Application No: A/193/20/PL
Site Address: Ham Manor Cottage Ham Manor Way Angmering BN16 4JQ
Description of works: Erection of a 1 No. 3 bedroom chalet bungalow & detached garage. This site is in CiL Zone 3 and is CIL Liable as dwelling.

OBJECTION TO PLANNING APPLICATION ARUN D C A/193/20/PL
HAM MANOR COTTAGE, HAM MANOR WAY, ANGMERING

Revision:	A	Dec 2020	Dimension added
address	Ham Manor Cottage, Ham Manor Way, Worthing, West Sussex		
project	Proposed construction of 3 bedroom detached property with detached double garage		
title	Proposed Block Plan		
scale	date	dwg no.	revision
1:200 on A4		2020.275.02	A

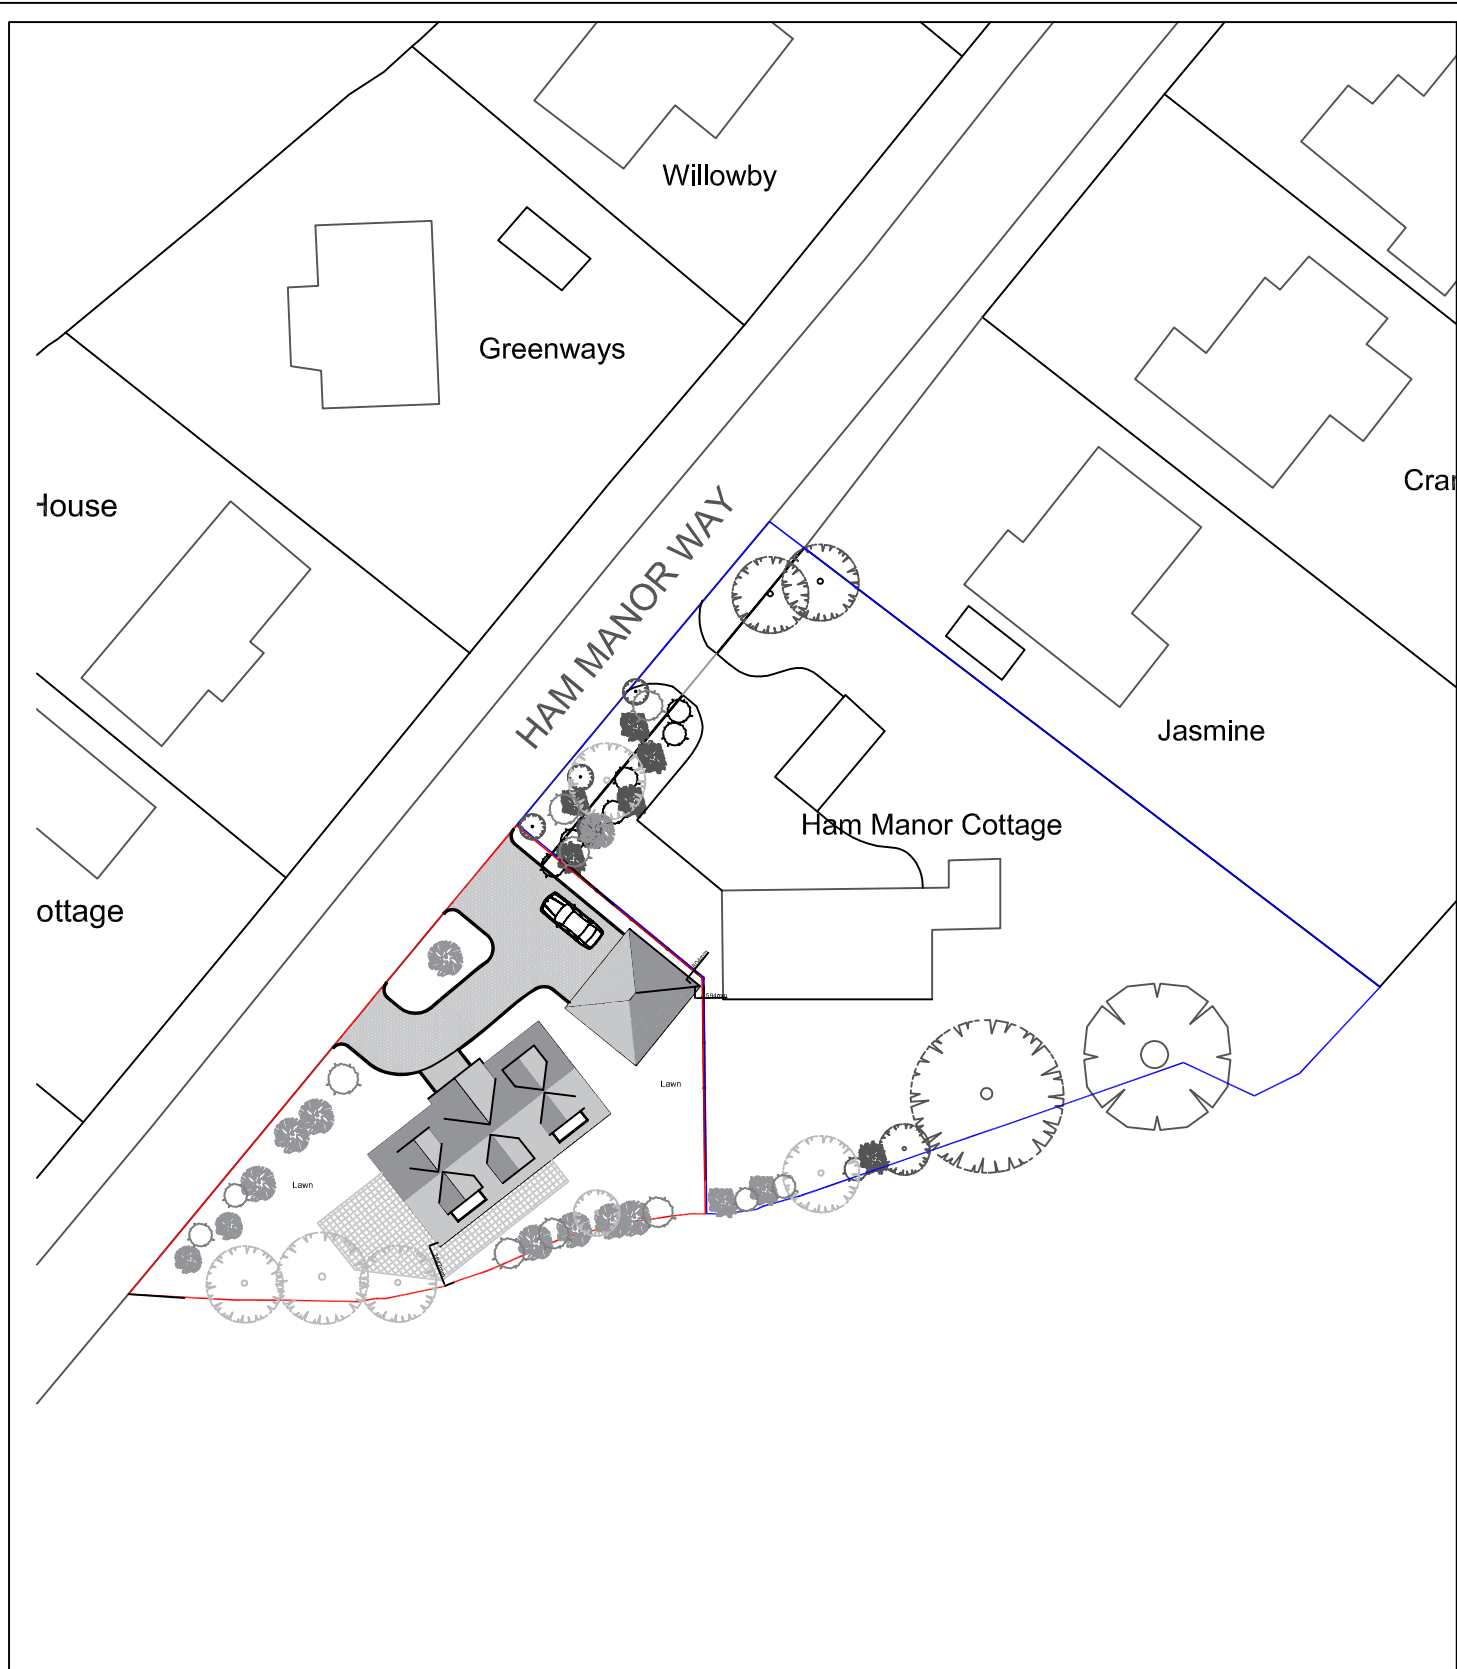
4. I carried out extensive extensions to my own property in 2000. The local architect pointed out specifically the building line explaining I couldn't build beyond that point. This was discussed in great detail BEFORE any drawings were created and in consultation with my neighbours on either side as a matter of common courtesy. I am unaware of any substantial changes in building line legislation at this moment in time.
